A585 Windy Harbour to Skippool Improvement Scheme

7.35 Responses to Representations at Deadline 8

RESPONSES TO REPRESENTATIONS RECEIVED AT DEADLINE 8

Regulation Number:	Regulation 5(2)(q)
Planning Inspectorate Scheme Reference	TR010035
Application Document Reference	TR010035/APP/7.35
Author:	A585 Windy Harbour to Skippool Improvement Scheme Project Team, Highways England

Drawing Title ENVIRONMENTAL MASTERPLAN  
SHEET 9 OF 32

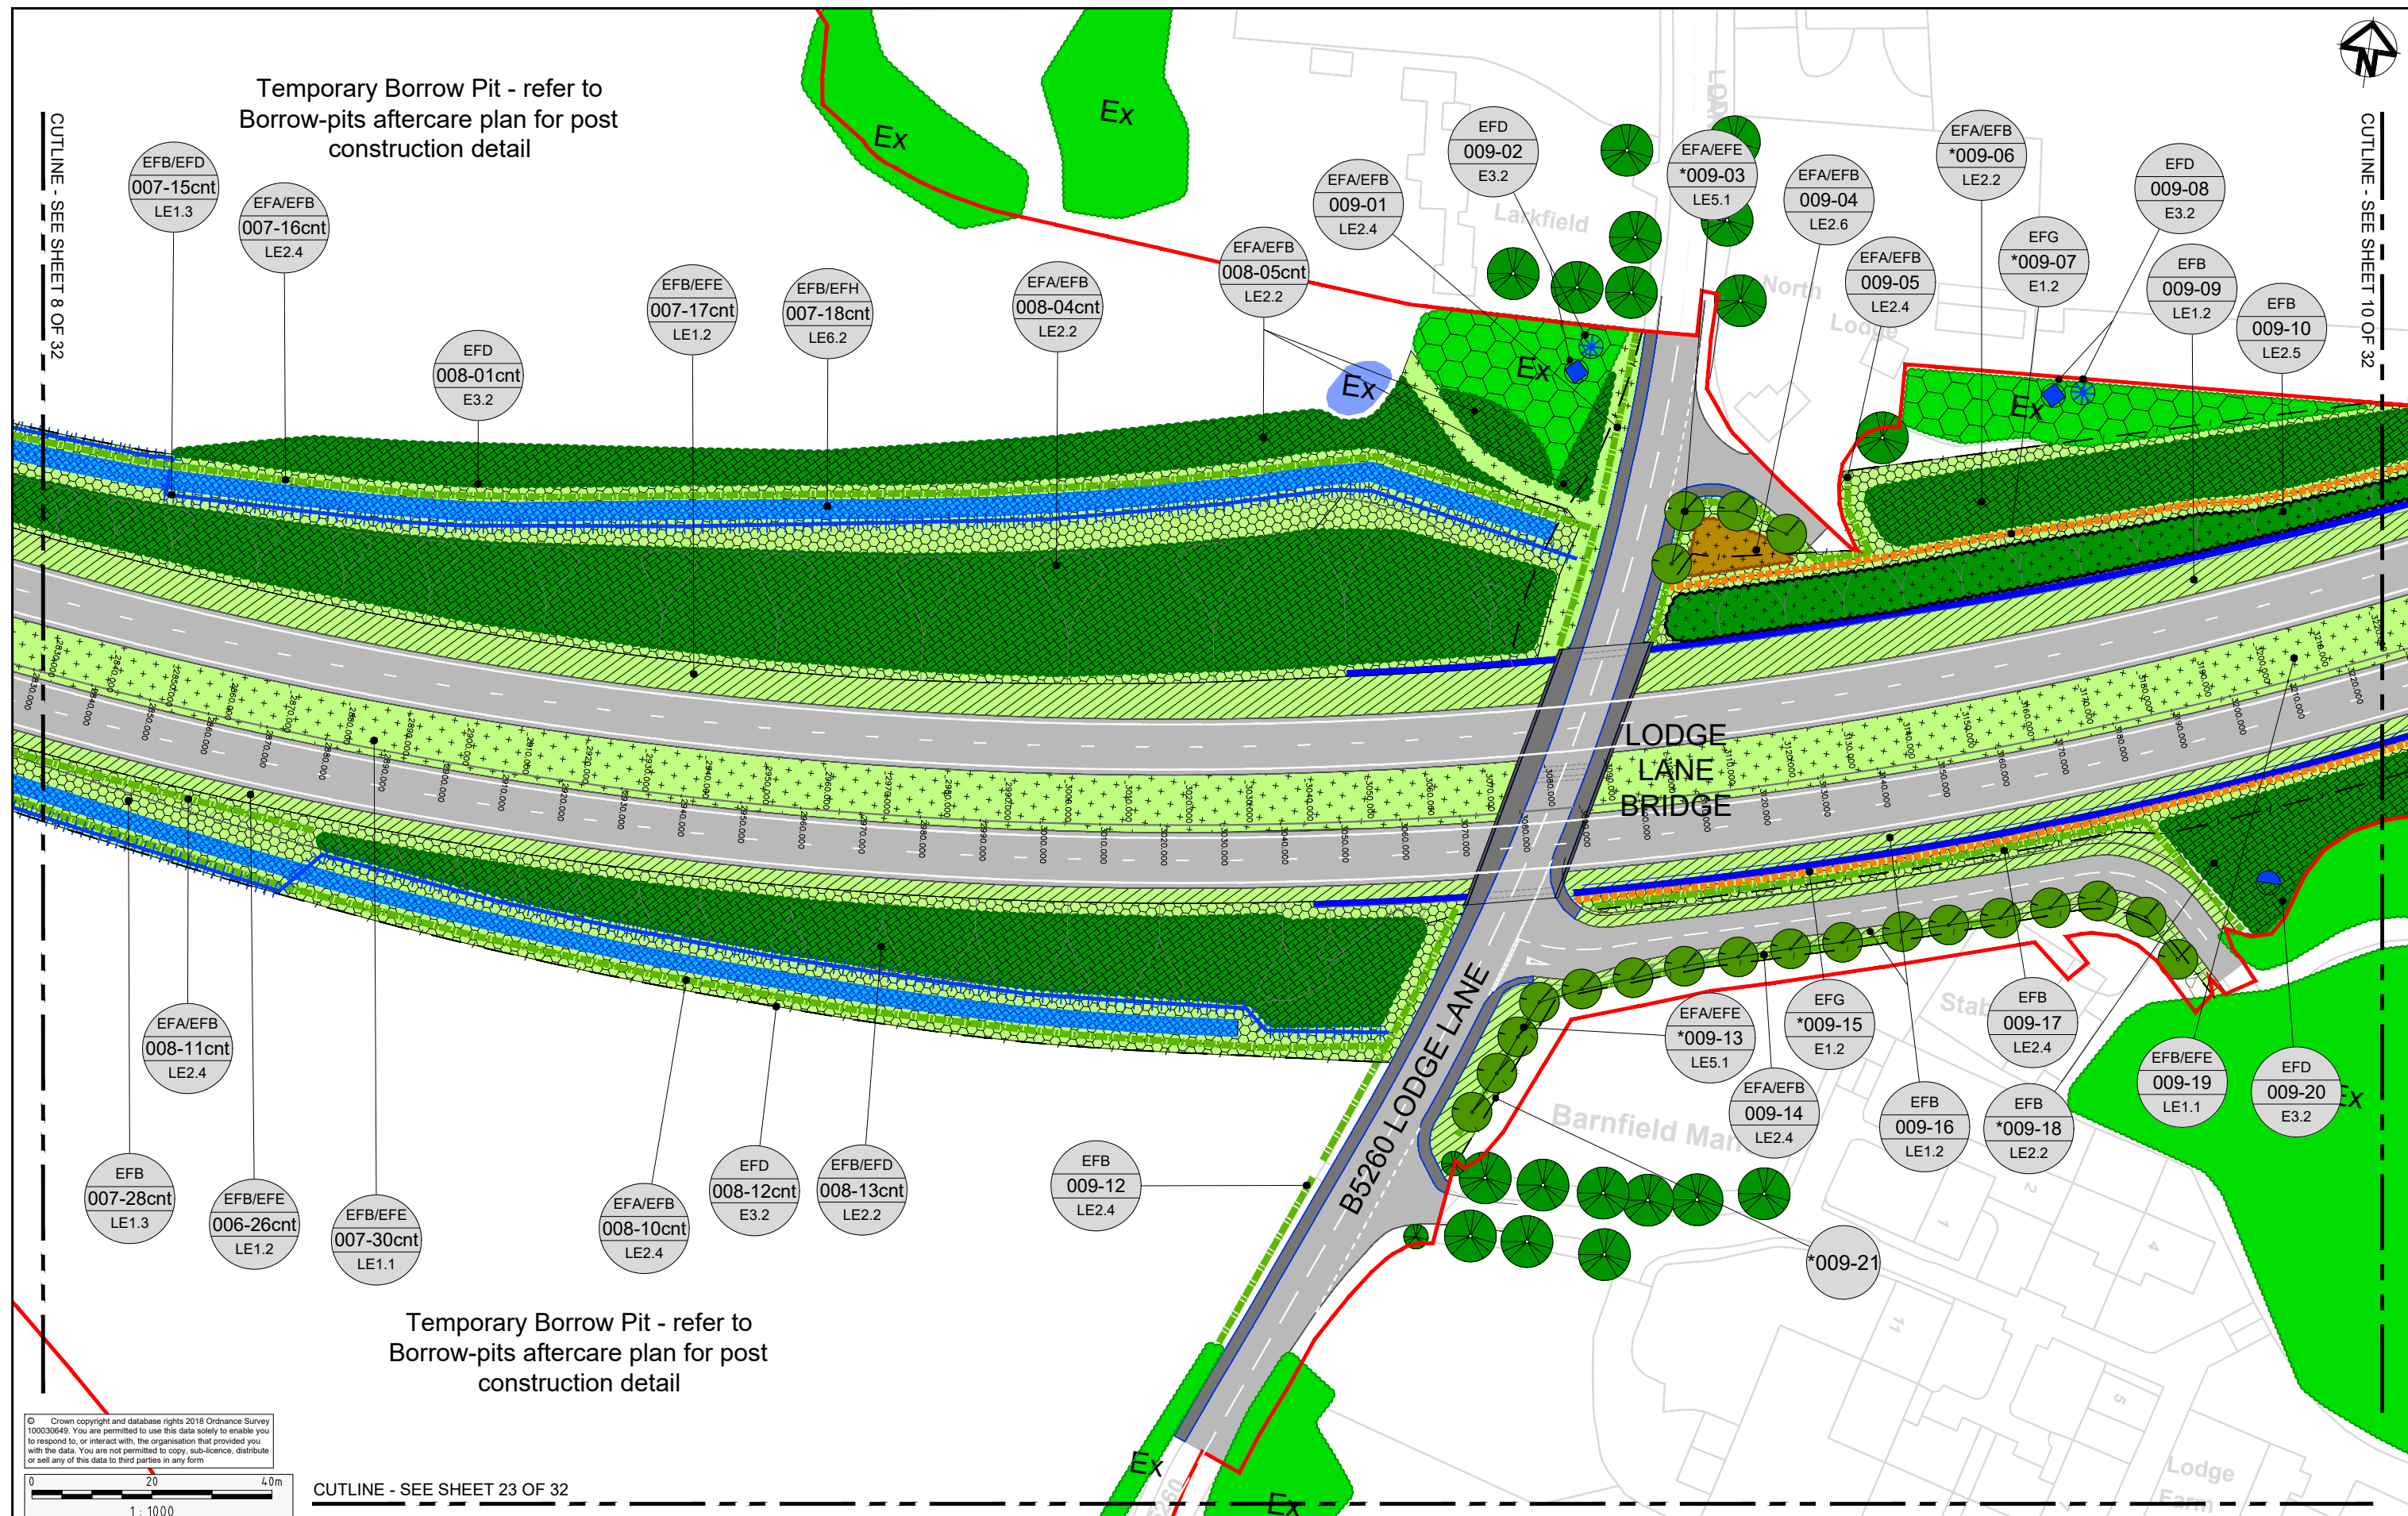
REP8-XXX-06	We also note from the Environmental Master Plan sheet 9 of 32 that the land lying to the north of the proposed bypass which will be retained by our clients has an extremely restricted and I would suggest probably unusable access. This access needs to be of suitable hard-core construction with dropped kerb to Lodge Lane (If it kerbed at this point) so that our clients can get in and out of the field at this new access point. It is also in an area where there appears to be Woodland Edge planting out with the acquisition area and to which we wish to object.	The Environmental Masterplan is indicative only at this stage. The Applicant notes the comment made by the landowner and confirm that the issues will be taken into account in the detailed design of the Scheme.
	Cadent	
REP8-XXX-01	Cadent Gas Limited (Cadent) is a statutory undertaker for the purposes of the Planning Act 2008 (PA 2008) and is providing comments on the final form of draft DCO (dDCO) submitted by the Promoter.	The Representation is noted. The Applicant refers to its submission at Deadline 8 (TR010035/APP/7.33).

HM Land Registry Current title plan

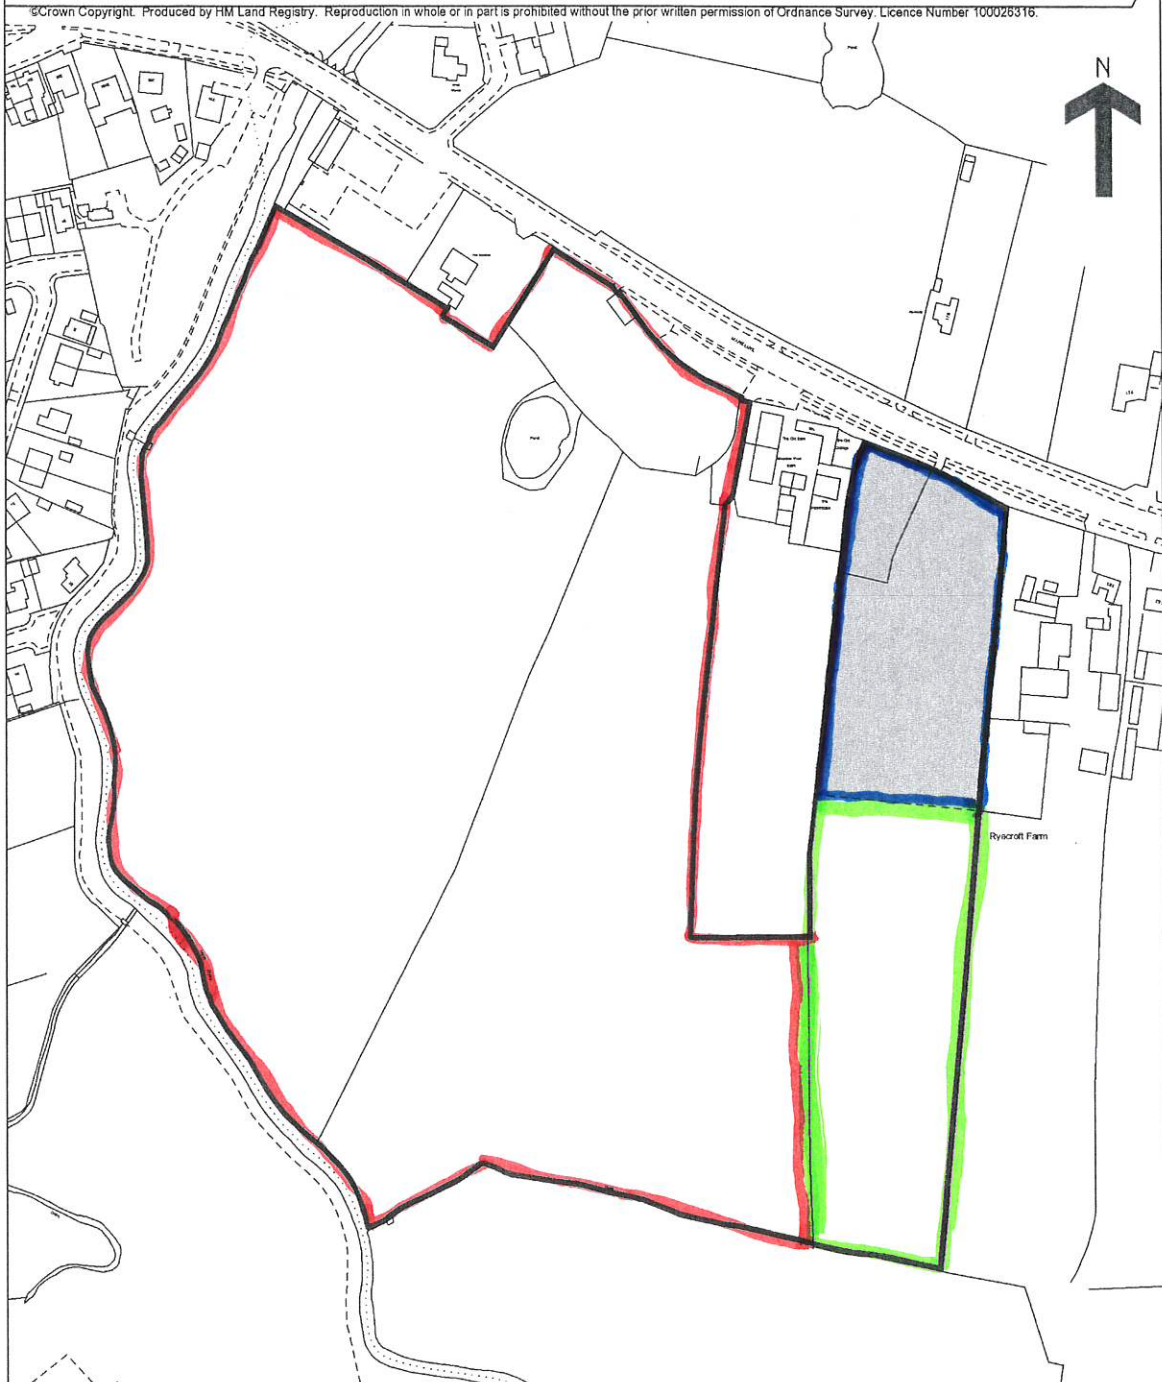
Carrington Group Mains Lane Limited	
REP8-XXX-01	<p>As previously confirmed, Carrington is the registered proprietor of the land shown edged red, blue and green on Plan 1 (the "Land"). For the purposes of these representations the land coloured red is "Parcel 1", the land coloured blue is "Parcel 2" and the land edged green is "Parcel 3".</p> <p>The Land is affected by the proposed route of the Scheme as the Scheme will</p> <ul style="list-style-type: none"> i) stifle development proposed for the Land, ii) prevent current use of large parts of the Land and iii) have an onerous effect on the value of the Land. <p>This letter contains further representations in addition to those which have previously been submitted by, or on behalf of Carrington throughout the Application process and examination timetable including, for the avoidance of doubt, the letter dated 24 January 2019 sent by Eversheds on behalf of Carrington to the Planning Inspectorate (the "January Correspondence") and all relevant representations submitted.</p>	<p>The Applicant notes the comments made by Carrington which have been raised previously and orally at the Compulsory Acquisition Hearing. The Applicant responded to the comments on those occasions, please refer to RR-008 in Comments on Relevant Representations (document reference TR010035/APP/7.9), ExQ 1.1.15, ExQ 1.8.7 in Responses to the Examining Authority's Written Questions (document reference TR010035/APP/7.10). Also 1.1.15 and 1.8.7 in Fylde Borough Council's Responses to ExA's First Written Questions.</p>

REP8-XXX-05	<p>At present, Carrington benefits from access to Plot 1 by way of a gated access way from Mains Lane measuring 10.5m in width, which is necessary for the passing of up to two agricultural vehicles at present and for access onto Mains Road from Parcel 1.</p> <p>The current access way was intended to be used by Carrington as the entrance roadway into a proposed future development of 150 dwellings and for all construction traffic during development. The existence of an access road measuring 10.5m in width was a material inducement to the acquisition of the Site by Carrington.</p> <p>Plans presented at the outset of the DCO process provided no access to Plot 1 which made it land locked with current and future uses sterilised. The Scheme plans were subsequently changed to provide an access to Plot 1 from the new carriageway to be constructed as part of the Scheme.</p> <p>The plans to the Scheme have now been varied as can be seen from the attached plan HE548643-ARC-GEN-SZ_ZZ_000DR-D-3065 ("Plan 2"). A new access way has been incorporated to provide access to Parcel 1 which is shown as being only 4.5m in width, some 6 metres narrower than currently exists.</p> <p>No explanation or reasoning has been given by Highways England (the</p>

Reference Number	Written Representations	Response to Written Representation
	<p>promoter of the Scheme) as to why Carrington is only being provided with a 4.5m width access to Parcel 1 and why there is no like for like replacement of an access way of the same width as currently exists.</p> <p>On the current Scheme plans Carrington will lose its 10.5m width access to Parcel 1, (a crucial feature of the Land and an inducement to the original acquisition by Carrington), and have it replaced with the 4.5m wide new access.</p> <p>The reduction in the access width is concerning and seems to lack discernible justification as no detail as to the reasoning that led to a decision to reduce the access width by 6 metres has been provided by Highways England. There is more than enough land contained within the limit boundary of proposed draft orders shown on Plan 2 for a sufficient like-for-like accessway of 10.5m width and no clear reasoning has been put forward as to why this is not acceptable and what basis in law or policy enables the subsuming and removal of essential access to Parcel 1 and replacement with an insufficient access which results in Parcel 1 being unusable.</p> <p>We can find no reference to any technical assessment undertaken by Highways England that would support its conclusion that a 4.5 metre wide access is appropriate for Parcel 1.</p> <p>The Manual for Streets prepared by the Department for Transport provides that carriageway widths should be appropriate for the particular context and uses of the street. Key factors to take into account include:</p> <ul style="list-style-type: none"> • the volume of vehicular traffic and pedestrian activity; • the traffic composition; • the demarcation, if any, between carriageway and footway (e.g. kerb, street furniture or trees and planting); • whether parking is to take place in the carriageway and, if so, its distribution, • arrangement, the frequency of occupation, and the likely level of parking enforcement (if any); • the design speed (recommended to be 20 mph or less in residential areas); • the curvature of the street (bends require greater width to accommodate the swept path of larger vehicles); and • any intention to include one-way streets, or short stretches of
